HOTHERSALL PARISH COUNCIL

26 August 2022

RE: 3/2022/0553 Higher College Farm, Lower Road, Longridge PR3 2YY

Drawing Title
Proposed Site Layout Plan

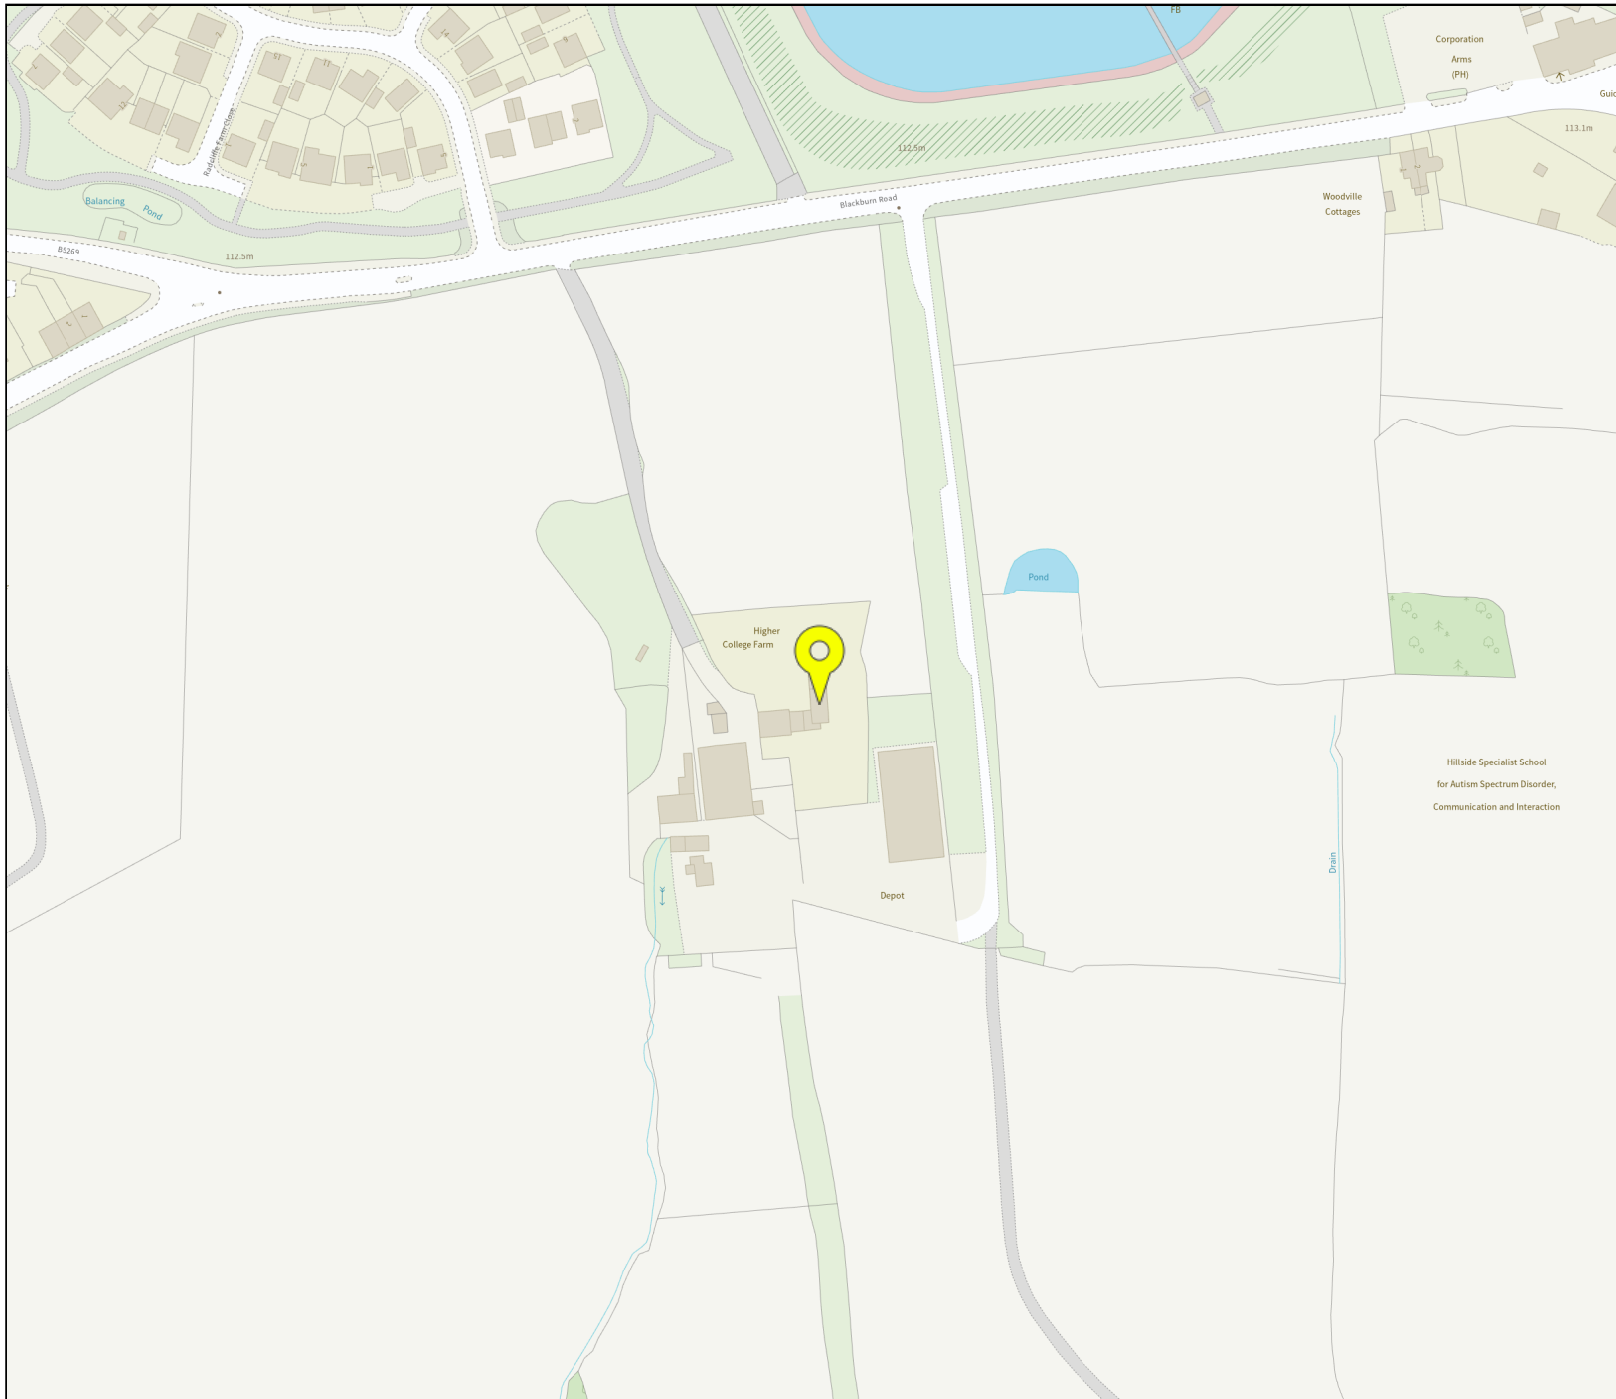
- 1 The stated Car Parking provision appears to be inadequate, with a shortfall of approximately 50 spaces. If confirmed, this would lead to a risk of parking on the surrounding verges, which, in turn, would obscure sightlines for manoeuvring traffic;

- 2 The potential increase in number of journeys to the site eg,, for the use of the proposed gym, could be considerably higher than the number of car parking spaces suggests;

- 4 The detail that the site access is tracked for 16.5m articulated lorries for deliveries must be based on an assumption that this size and number of vehicles will use the roads through Longridge (eg Chapel Hill) and Ribchester (eg Blackburn Road). These roads are unsuitable for such traffic and any increase in its volume will create problems for these points on the route;
